HERBATA DATA CENTRE, NAAS-RESPONSE TO REQUEST FOR FURTHER INFORMATION ("RESPONSE TO RFI") FROM KILDARE COUNTY COUNCIL

ADDENDUM TO CHAPTER 10 CULTURAL HERITAGE

NI2615
01
June 2025

Figure 10.16: Close up of project design showing location of the enclosure identified in Field 8 during the geophysical survey

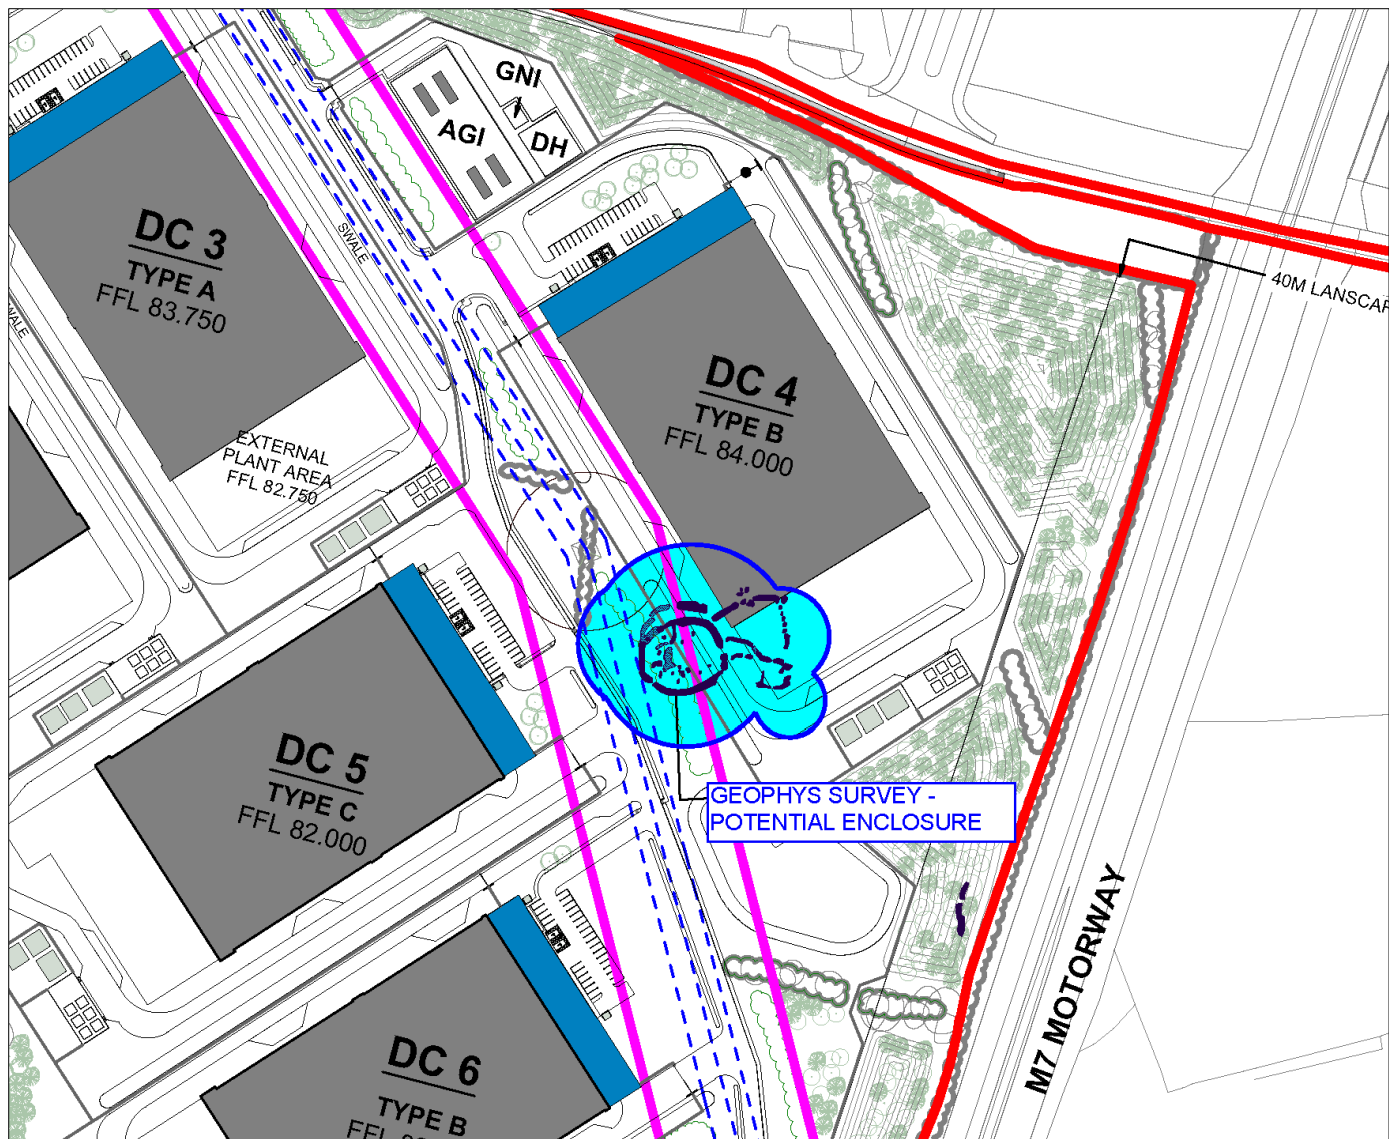
The submitted design involved encroachment of the southern portion of Date Centre 4 and its external ancillary elements, such as a swale and access road, into the area containing the enclosure feature identified during geophysical survey (referred to as 'new archaeological monument' in the RFI from Kildare County Council).

The Kildare County Council RFI (Item 25) requested a *comprehensive interrogation of design options to determine the feasibility of facilitating preservation in situ of this monument and submit a detailed report detailing the results of an assessment of all design options.*

The amended layout of Data Centre 4 will allow for the preservation of the enclosure feature which comprises of a circular ditched feature (c.31m diam.) with multiple internal features and two sub-rectilinear annexes, extending c.25m to the east of the main enclosure *in situ*. The proposed amendment to Data Centre 4

The area preserved in situ is surrounded by a 10m exclusion zone extending from the outer edge of the identified enclosure feature. This exclusion zone shall be fenced-off and remain an exclusion zone throughout both the construction phase and operational phase of the project (a cross section illustrating the exclusion zone is provided in drawing 2232-DOB-ZZ-ZZ-DR-C-0600, Proposed Site Sections, Vol III).

The most notable amendment is to the overall building shape of Data Centre 4, however due consideration has been given to all built elements within the locale of the enclosure feature, in order to ensure that drainage and road infrastructure, external plant compounds, security fencing, landscaping and temporary construction compounds, remain outside the exclusion zone.
